**From:** Christina Wollman  
**Sent:** Wednesday, March 05, 2014 11:07 AM  
**To:** Lindsey Ozbolt  
**Subject:** RE: red's fly shop  
**Attachments:** 201403051021.pdf

The documents for the trap shooting CUP say there is an approved access permit for parking. ACP 5359. Could you send me a copy of it? Also, is everything taken care of with WSDOT by the applicant for this project, or do you have any additional conditions prior to approval of the CUP?

RED'S FLY SHOP CONDITIONAL USE PERMIT - CU-13-00003

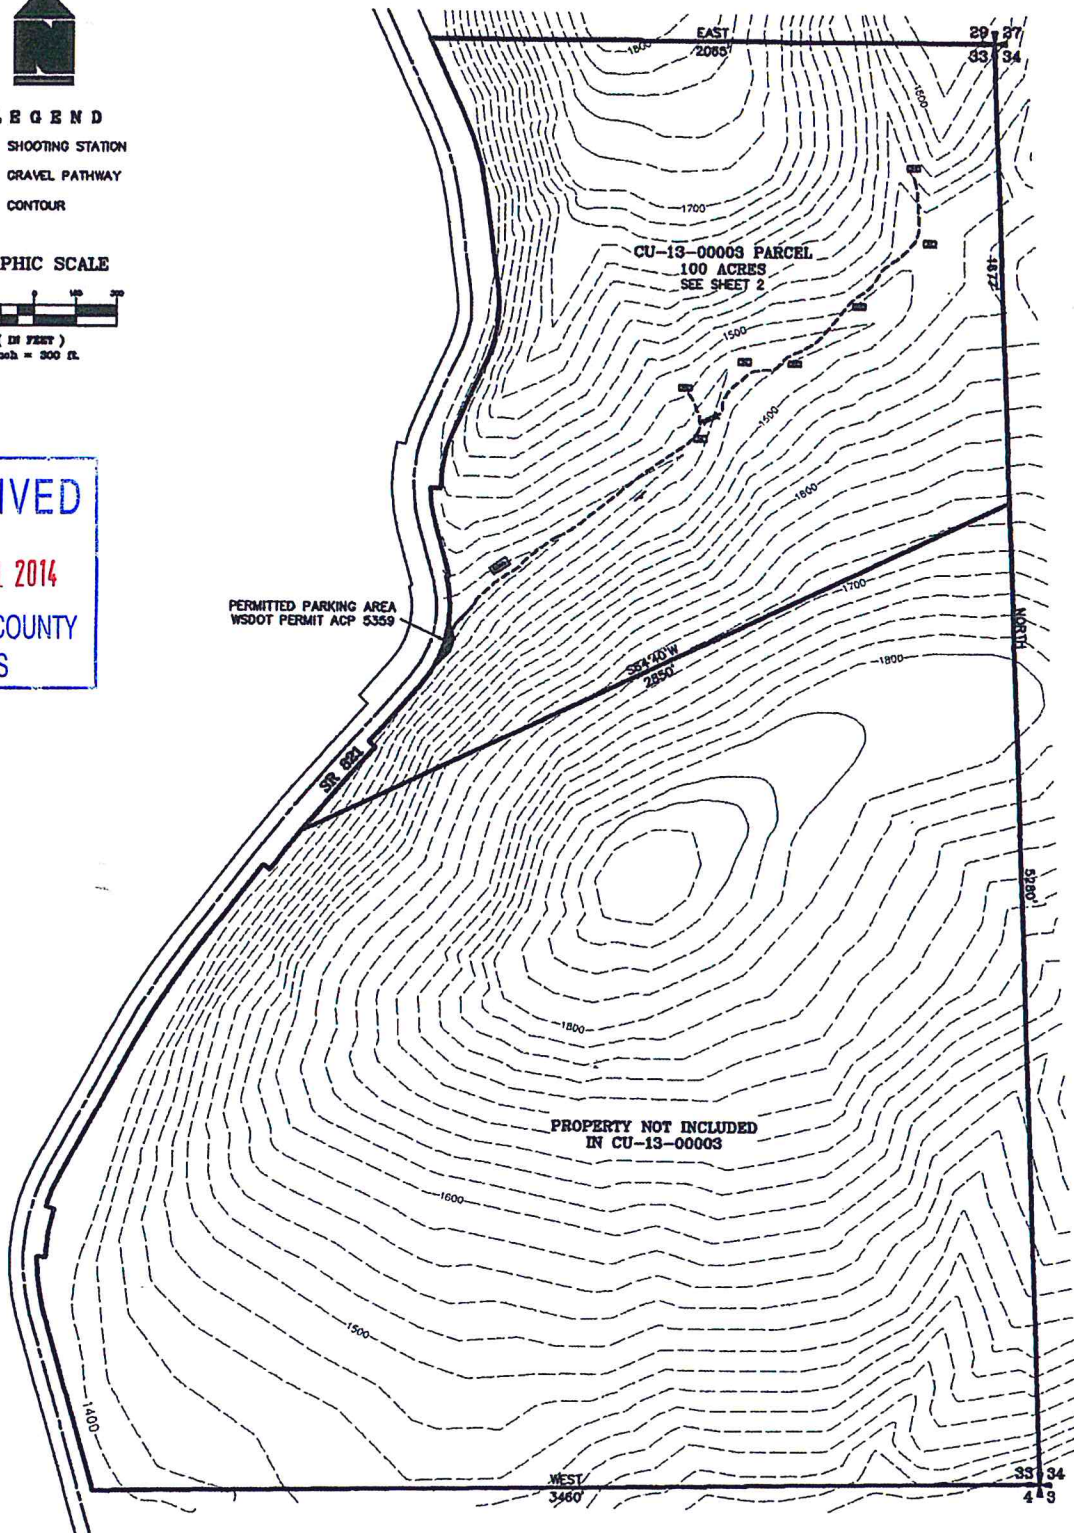
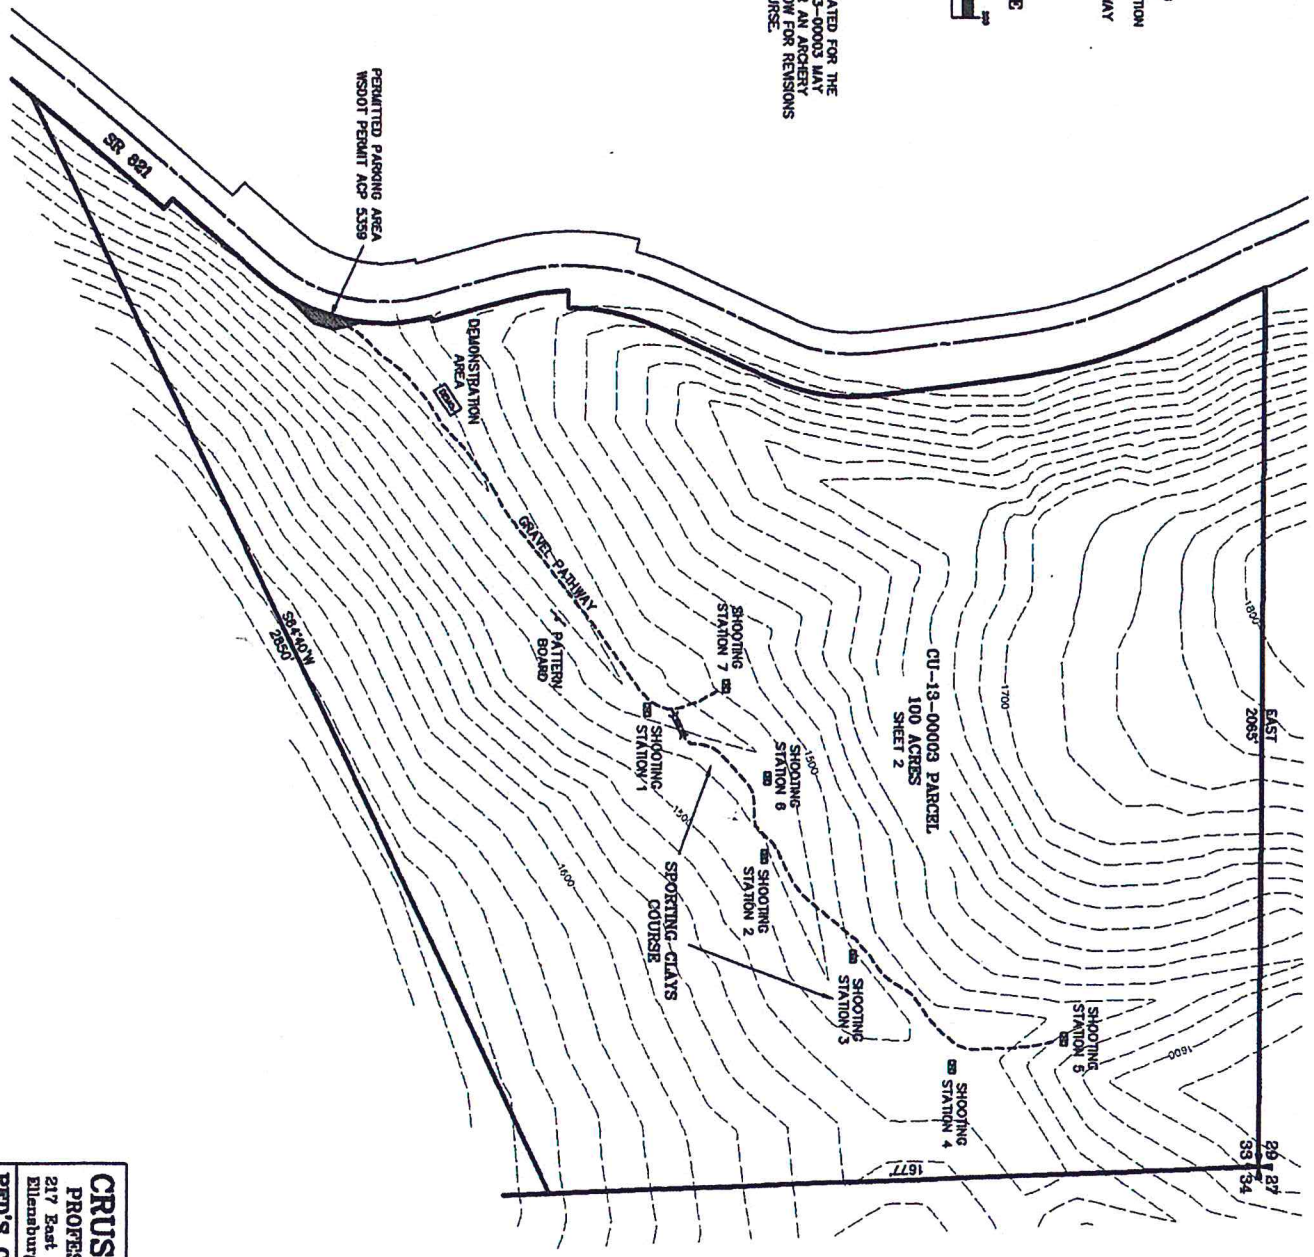
Lindsey, here is the WSDOT access permit that was noted on the drawings. A condition requiring them to comply with the WSDOT access permit conditions would probably be good.

The access permit allows three parking spaces, the application states 4-6. Beyond this, public works has no other comments.
